# Stonestreet Green Solar

## Responses to Deadline 6 Submissions

PINS Ref: EN010135  
Doc Ref. 8.21  
Version 1  
Deadline 7  
May 2025

Figure 13.3: PRow Survey Results - Daily PRow Trips

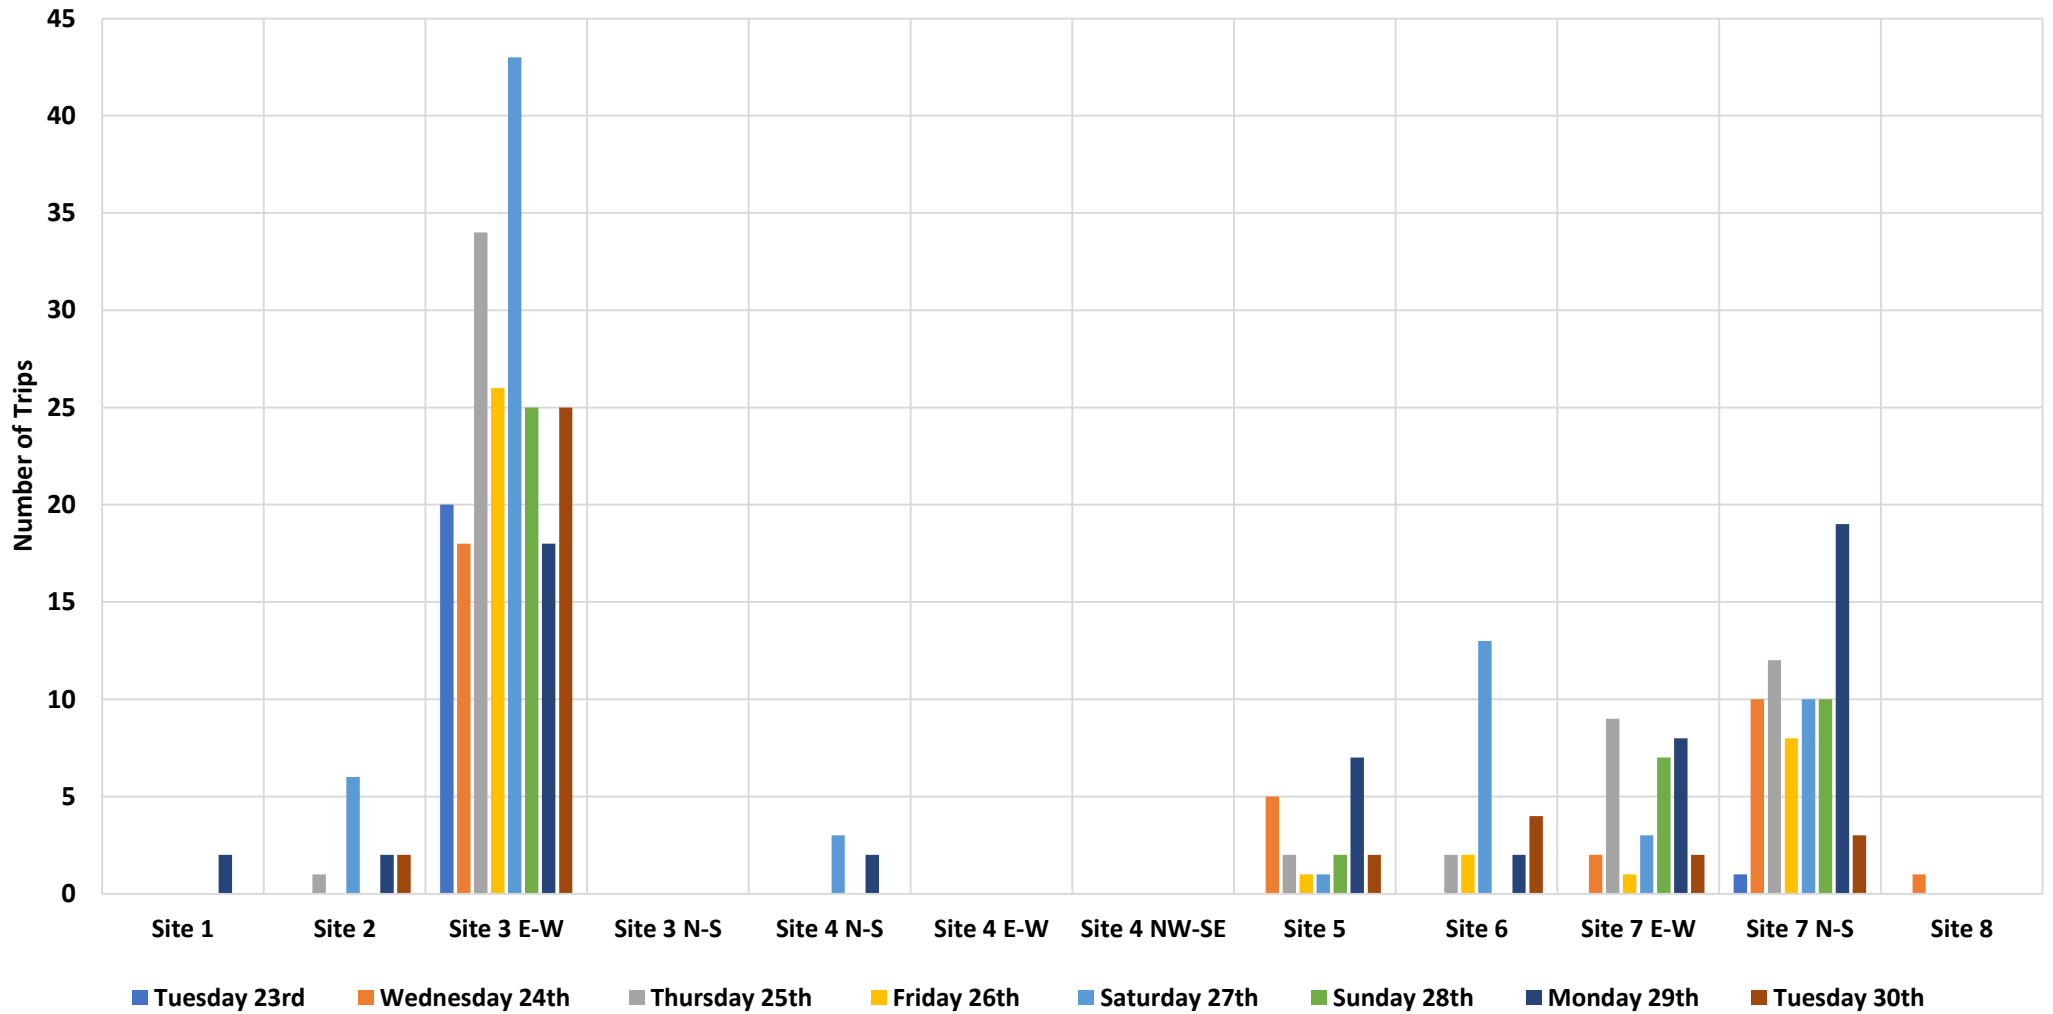
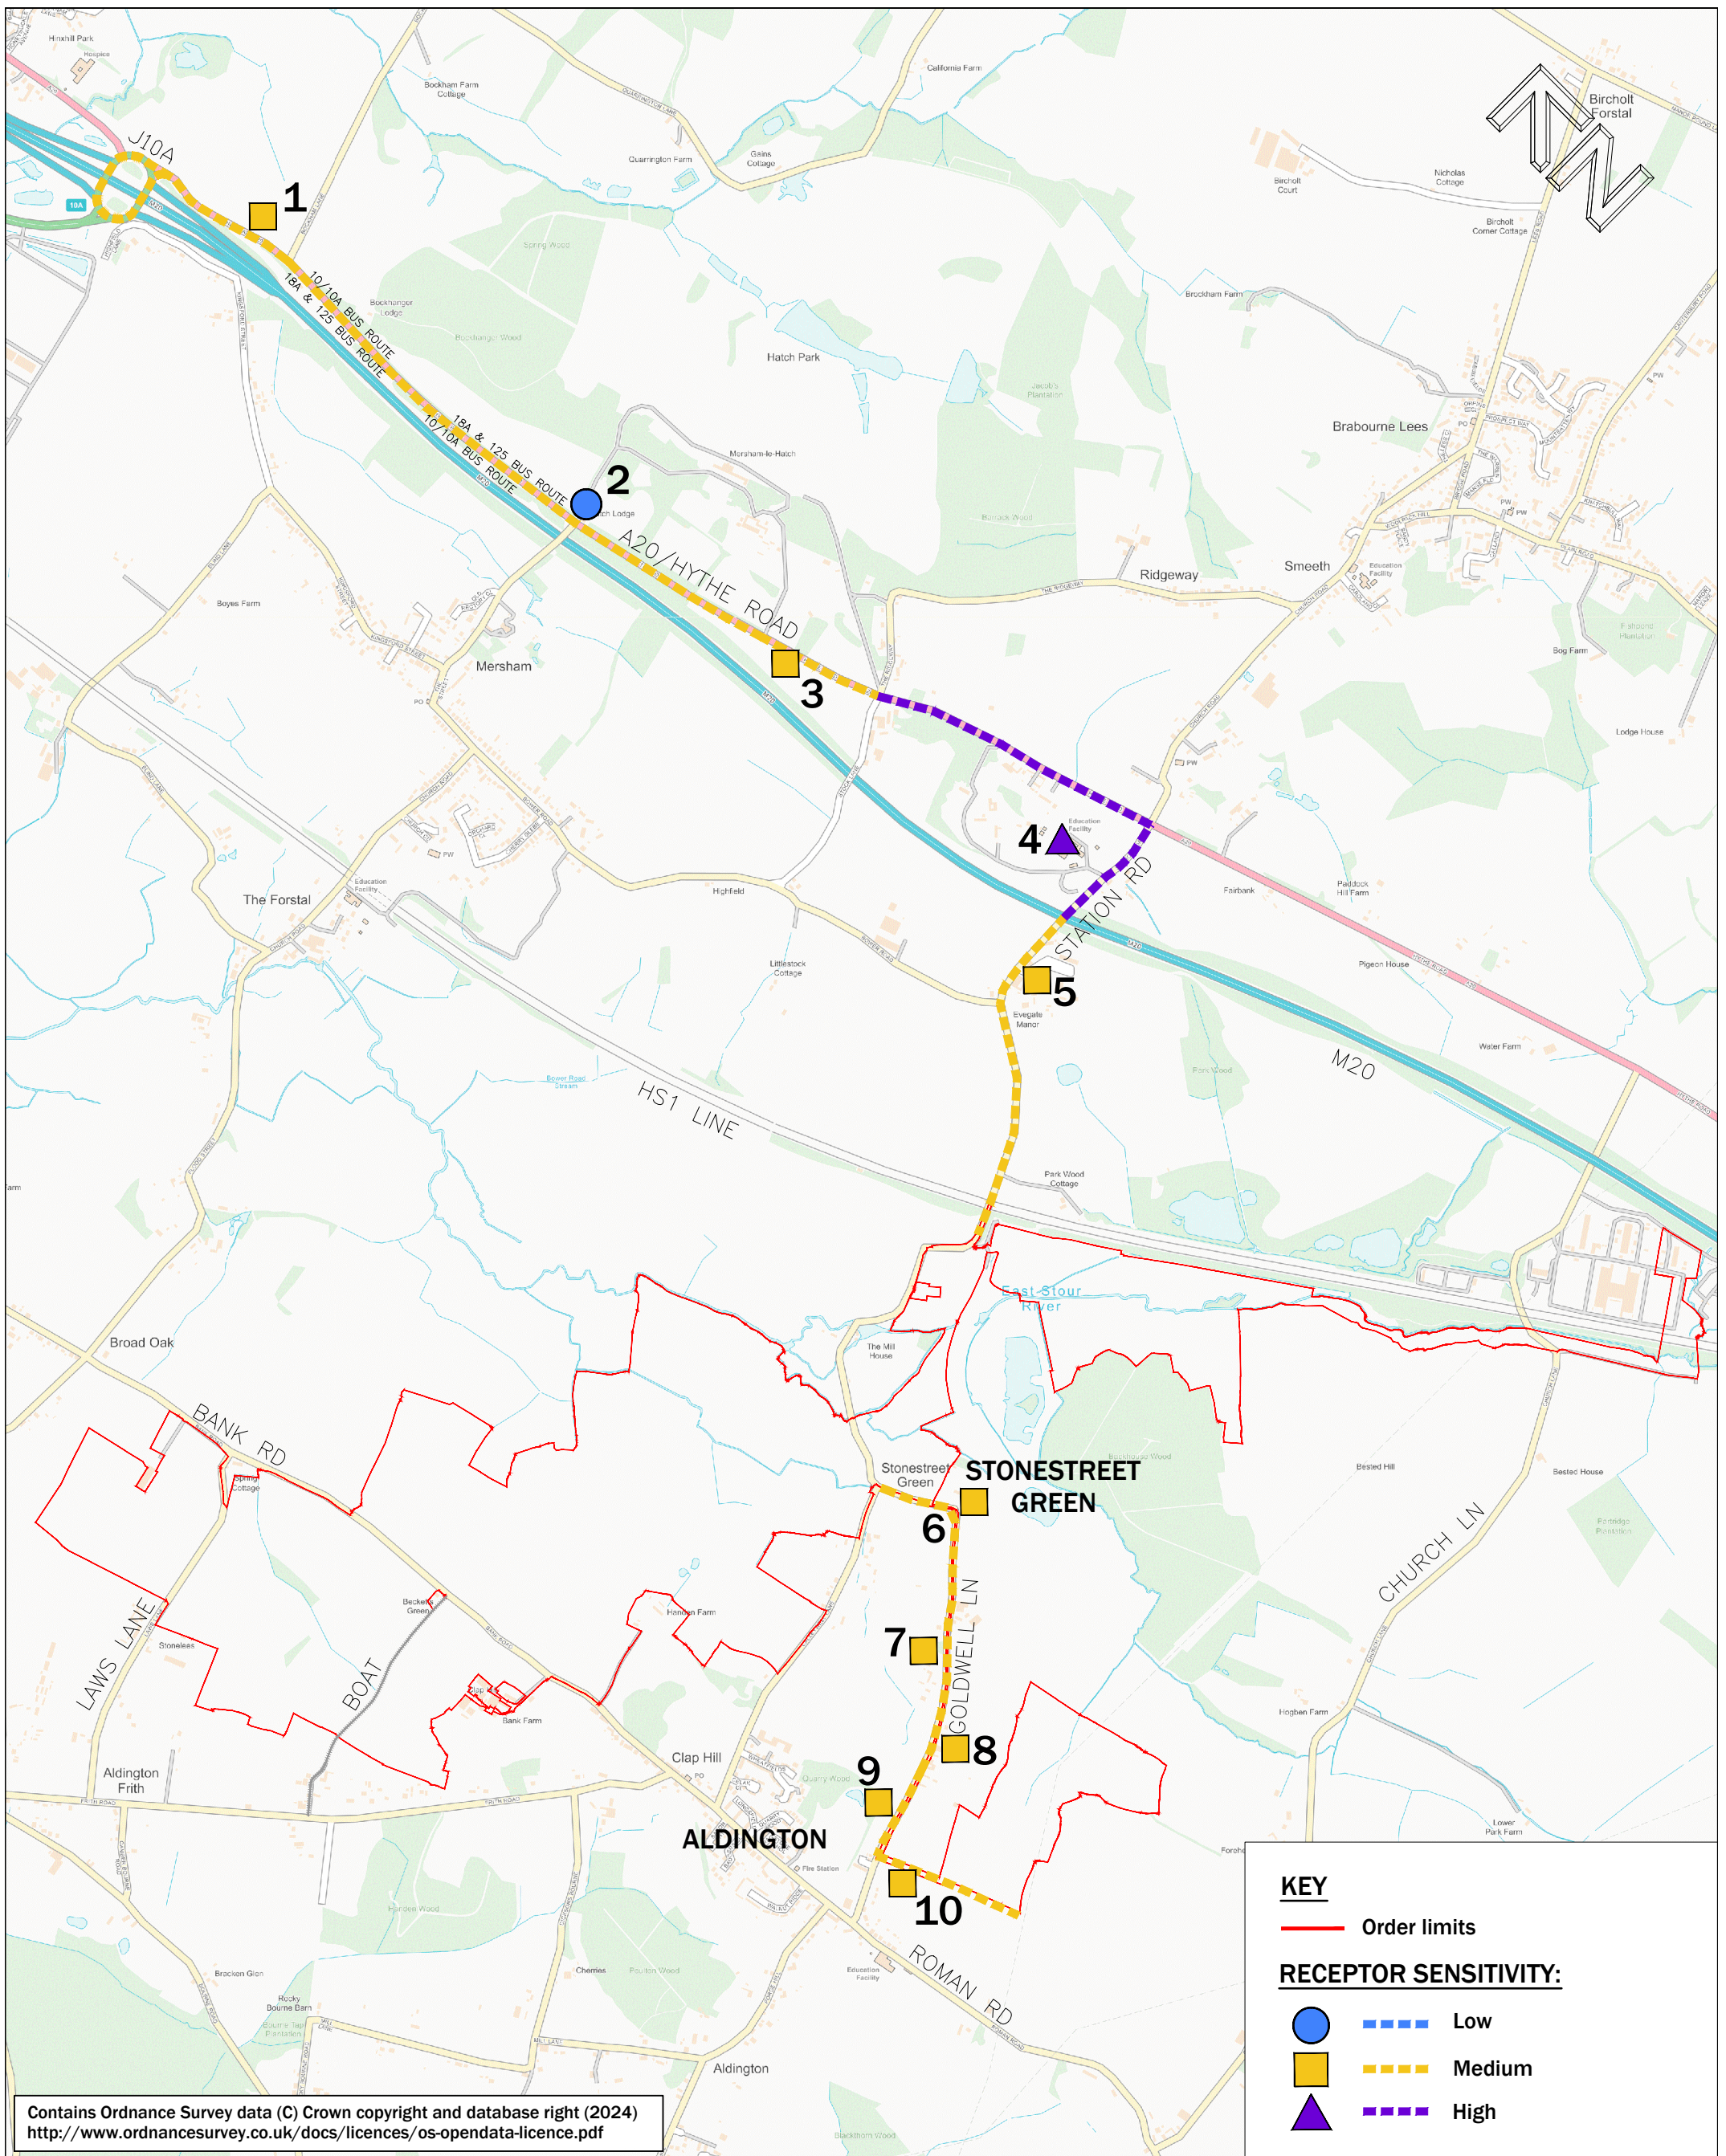
Ref	Summary of Interested Party's Comments	Applicant's Response
<i>PRoW</i>		
1	<p>In respect of the use of the PRoW network a survey was undertaken by the applicant. 8 survey points were used and those locations agreed in advance. In-situ cameras were used for a period of 7 days.</p> <p>I think that it would be fair to say on the basis of the survey and our interrogation of data available to us, that the network is relatively lightly used in comparison with networks that fringe on more urban areas or include routes that are actively promoted.</p> <p>However, the level of use of PROW in a given period is largely irrelevant:</p> <p>Use can be sporadic, weather dependent and fluctuate as a result of numerous additional factors – e.g. the timing of vegetation clearance (Highway Authority responsibility) , promotion of a walk, local events etc, the use of preferred local alternative alignments. You can readily deviate from PROW in a way that you can't from a road.</p> <p>Irrespective of the above the area is set to change significantly over the life of the development. Otterpool would introduce approx. 8000 new homes and 20000 people on the “doorstep” of the scheme.</p> <p>Aldington and Sellindge will also, no doubt, expand. To the west Ashford is set to expand further and sits</p>	<p>The Applicant welcomes the acceptance in KCC’s submission that:</p> <ul style="list-style-type: none"> <li>a) the location to user surveys for PRoW has been agreed; and</li> <li>b) it is agreed that the network is relatively lightly used in comparison with networks that fringe on more urban areas or include routes that are actively promoted.</li> </ul> <p>The Applicant notes that KCC state that the level of use of PROW in a given period is largely irrelevant. The Applicant disagrees with this statement on the basis that the user survey and the timing for it to be undertaken was consulted in advance with KCC as noted in Table 13.2 of <b>ES Volume 2 Chapter 13: Traffic and Access</b> <a href="#">[REP3-012]</a>).</p> <p>The Applicant notes that – in terms of the consideration of cumulative effects (relating to Otterpool) – as set out in the Applicant’s <b>Written Summary of Oral Submissions from Issue Specific Hearing 3 and Responses to Action Points (Doc Ref. 8.14.1)</b> <a href="#">[REP4-030]</a>: <i>“The Project will deliver six new routes and enhancements to the existing network ... It will also improve connectivity in the north of the Site, providing better links between the Otterpool Park development and Ashford, a strategic route that KCC and ABC had made clear was important”</i>. These enhancements are set out and secured by the <b>Outline RoWAS (Doc Ref. 7.15(A))</b> <a href="#">[REP1-056]</a> at Section 3. The Applicant considers that it has therefore fully complied with paragraph 2.10.44 of NPS EN-3 in this regard. An assessment of cumulative effects on PRoW – including consideration of Otterpool (Cumulative scheme ID No. 10) – is set out within <b>ES Volume 2, Chapter 12: Socio-Economics (Doc Ref. 5.2(B))</b> <a href="#">[REP1-024]</a>. This does</p>

Ref	Summary of Interested Party's Comments	Applicant's Response
	<p>in close proximity to the scheme. The network will therefore no doubt see a growth in use as it becomes a recreational resource close to a significantly larger population.</p> <p>Strava is a running , cycling and hiking app that maps the routes taken by users, the data from which we are able to access by agreement.</p> <p>ActiveXchange is a software provider that is able to provide movement data derived from phone geolocation. (Similar to strava but drawing from a far greater number of apps.</p> <p>Strava figures were just for 2024 .Looking at the network of paths across site, there were 395 trips, focussed mainly during the summer months (April to September), made by 80 people. These were predominantly earlier in the day (6am to 9.30am). We know that Strava accounts for around 8-9% of total journeys made for busy areas, such as Medway Towpath in the middle of Maidstone, and is probably more representative of around 6-7% of total use in more rural areas, either of which would create a significant uplift in number of people/ trips made.</p> <p>ActiveXchange, backs this up. I've used the available 100m data squares, across the network of paths on site(broadly the same network area as above). Data is for the last three years and shows a higher level of activity (see below). This is most likely down to the different demographic</p> <p>ActiveXchange draws upon i.e., the user-base is</p>	<p>not include a consideration of speculative assertions of potential development that do not fall within the remit of the EIA Regulations.</p> <p>The Cumulative Schemes that have been considered in the ES were agreed with both ABC and KCC and are set out in <b>ES Volume 4: Chapter 6: Appendix 6.1: List of Cumulative Schemes (Doc Ref. 5.4)</b> <a href="#">[APP-068]</a>.</p> <p><b>ES Volume 2, Chapter 12: Socio-Economics (Doc Ref. 5.2(B))</b> <a href="#">[REP1-024]</a> at paragraph 12.10.10 then concludes that the cumulative schemes affecting PRow are in a significant distance from the Project, so the Project would not result in adverse effects on recreational amenity or connectivity.</p> <p>KCC has also submitted new evidence not previously included within representations, the Local Impact Report <a href="#">[REP1-087]</a> or other submissions to the examination on the usage of the PRow utilising data from Strava and ActiveXchange. KCC states that:</p> <ul style="list-style-type: none"> <li>- <i>“Looking at the network of paths across site, there were 395 trips, focussed mainly during the summer months (April to September), made by 80 people”</i> – The Applicant notes that this suggests extremely light usage.</li> <li>- <i>“We know that Strava accounts for around 8-9% of total journeys made for busy areas, such as Medway Towpath in the middle of Maidstone, and is probably more representative of around 6-7% of total use in more rural areas, either of which would create a significant uplift in number of people/ trips made”</i> – The Applicant considers that this claim is not evidenced or supported by quantitative data and therefore appears to be an assertion.</li> <li>- <i>“Data [from ActiveXchange] is for the last three years and shows a higher level of activity”</i> – The Applicant notes that the data presented appears to show an average of between 1-2 trips per hour over all of</li> </ul>

Ref	Summary of Interested Party's Comments	Applicant's Response
	<p>from a wider range of applications, than the self-selecting Strava demographic.</p> <p>Please refer the data figures from Strava and ActiveXchange in KCC's submission.</p>	<p>the routes within the figure provided, which again suggests extremely light usage when spread across the site.</p> <p>The Applicant notes that the data sources presented by KCC have limited relevance due to their sample size and distribution between individual links compared to in-situ camera surveys which were agreed between the Applicant and KCC.</p> <p>Overall, the Applicant considers the data survey presented by KCC is not relevant to the Examination given that the scope, timing and methodology of the Applicant's PRow User Survey has been agreed with KCC as set out in paragraph 13.4.51 of <b>ES Volume 2, Chapter 13: Traffic and Access (Doc Ref. 5.2(D))</b> <a href="#">[REP3-012]</a>. All the matters in relation to PRow and traffic surveys are also agreed with KCC as recorded in Table 2.2 of the <b>Statement of Common Ground with Kent County Council (Doc Ref. 8.3.4(D))</b> <a href="#">[REP6-006]</a>.</p>
